# One Earth Solar Farm

**Draft Statement of Common Ground with West Lindsey District Council**

**EN010159/APP/8.4.1**

~~July~~ August 2025

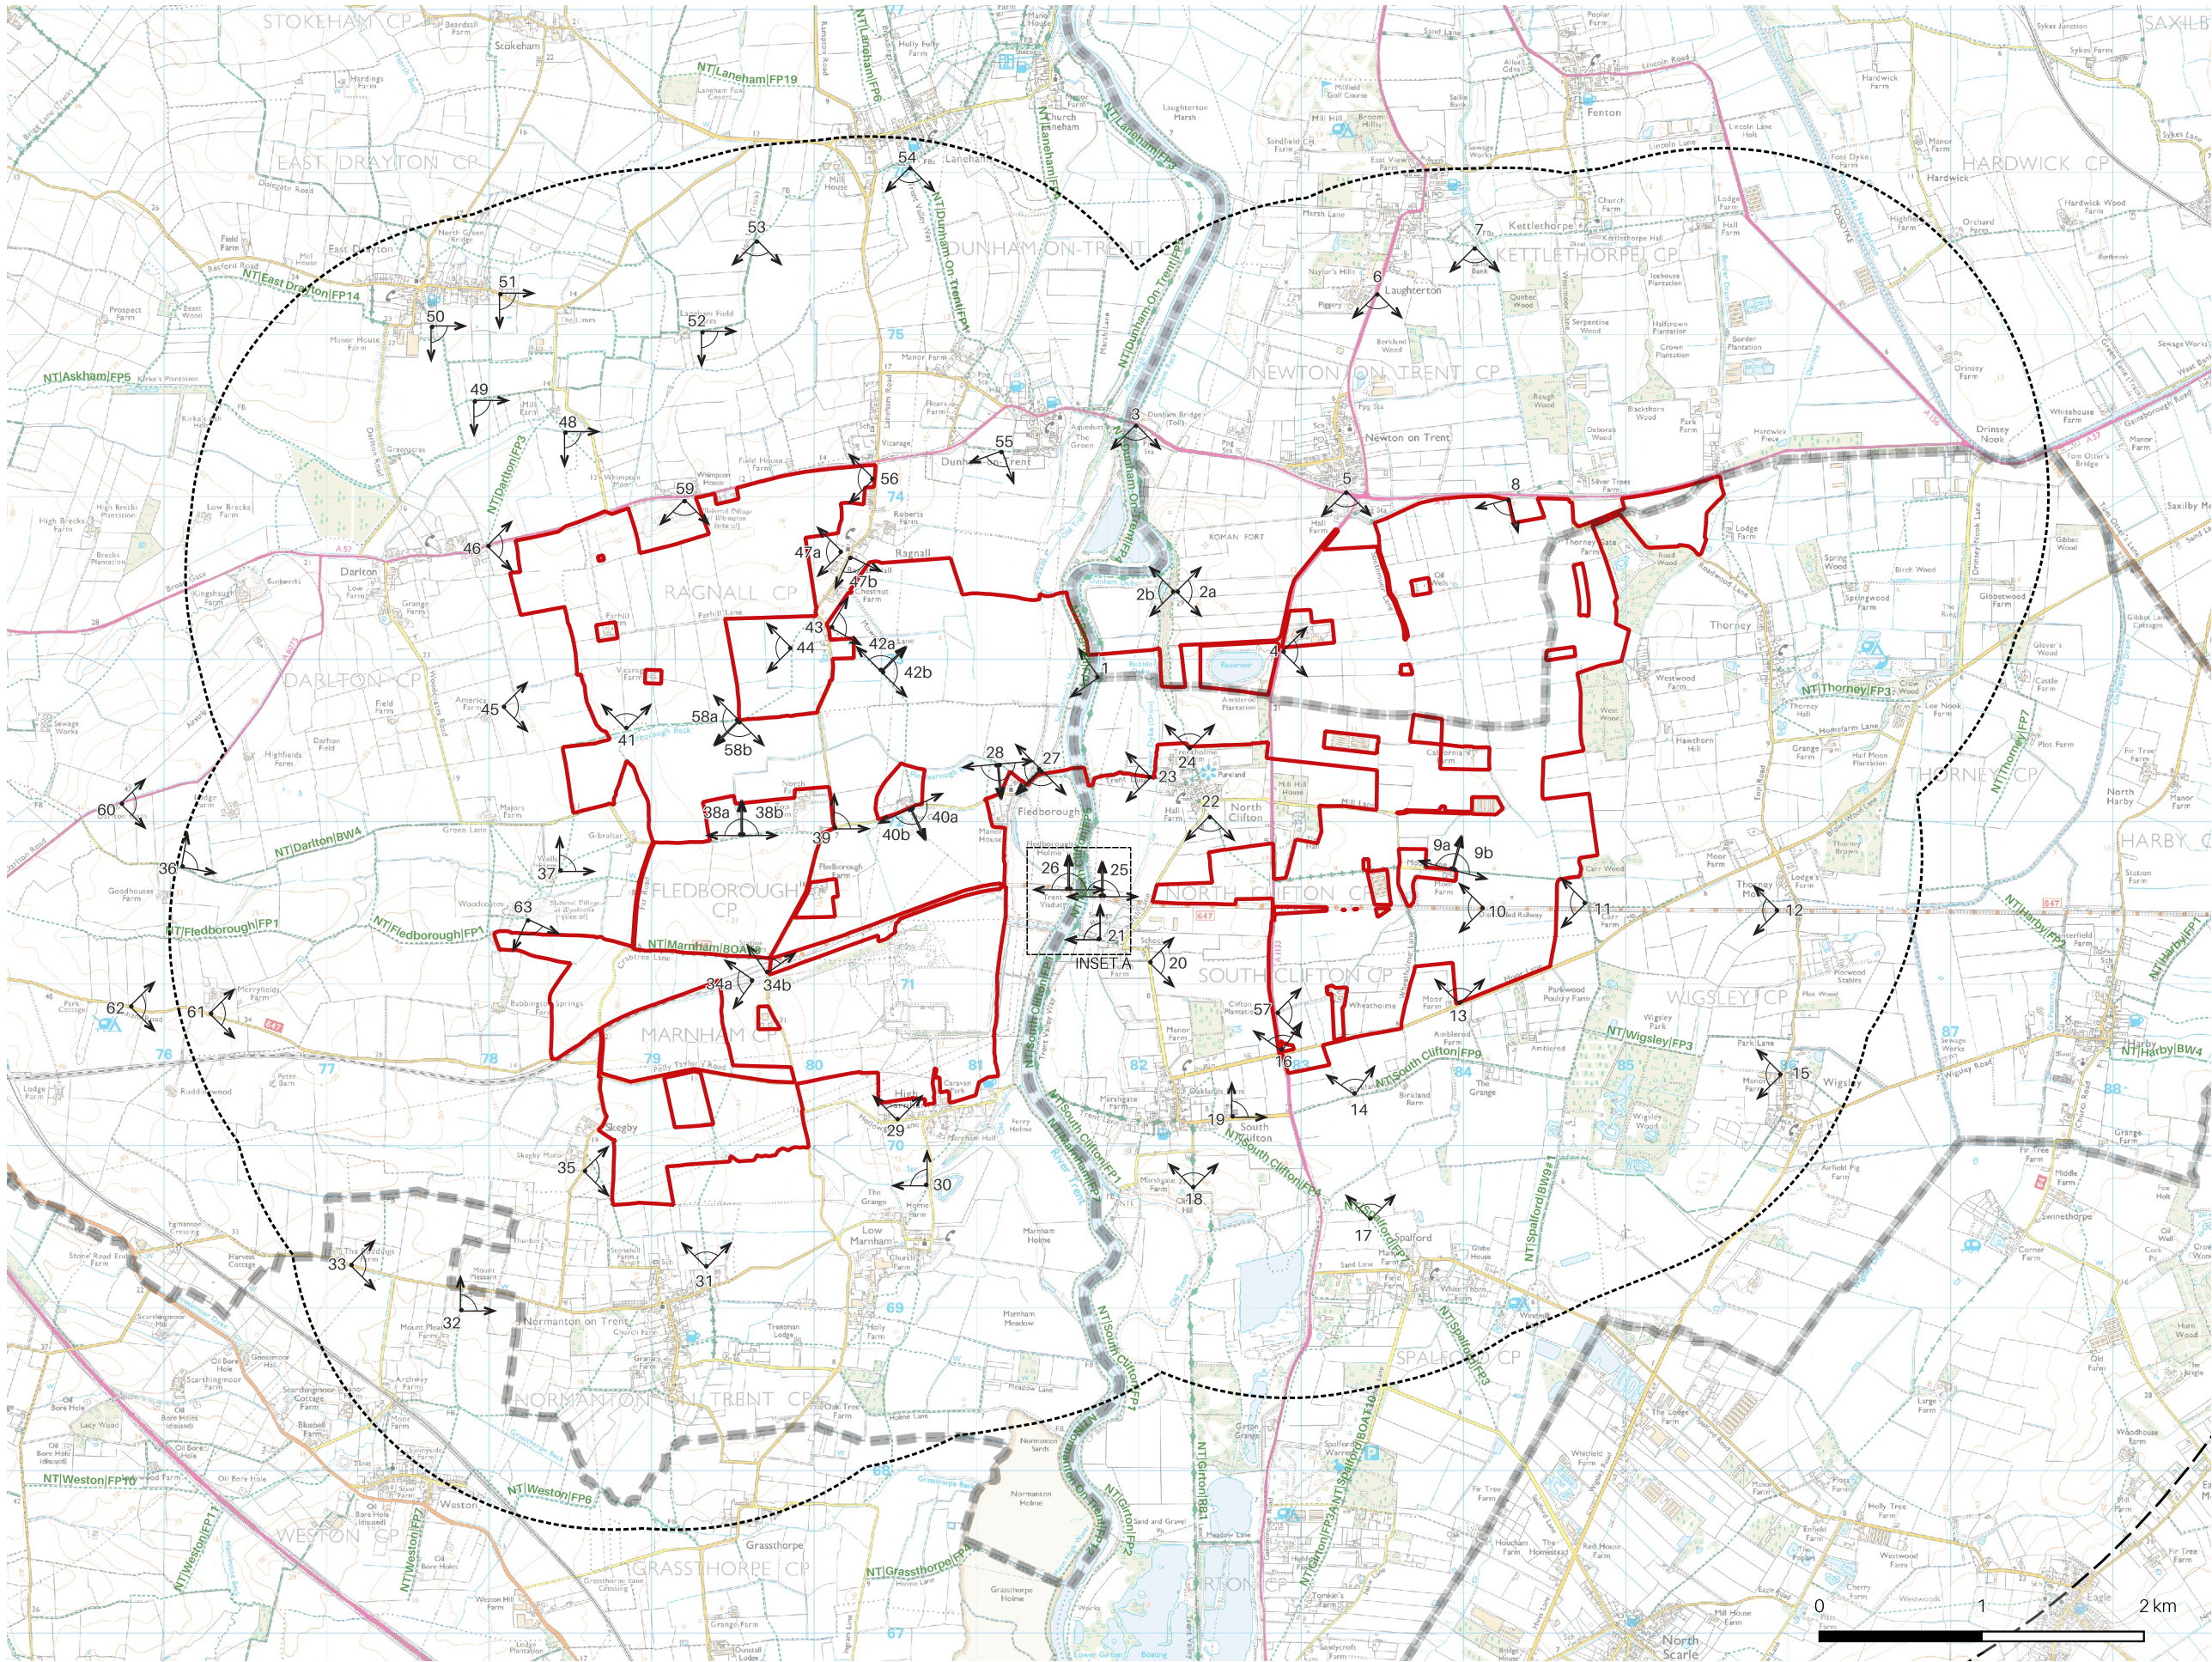
05-06	Scope of photomontages	West Lindsey District Council suggested an additional Type 4 photomontage from Viewpoint 8 along the A57 following review of the PEIR.  No further comments or concerns on the scope of representative viewpoints have been raised to date.	Further discussion was had between the applicant and the District Councils during the preparation of the LVIA ES Chapter regarding the scope of photomontages resulting in agreement that any justification for the photomontage scope should be included within the LVIA.	<u>Under discussion</u> <u>Agreed</u>
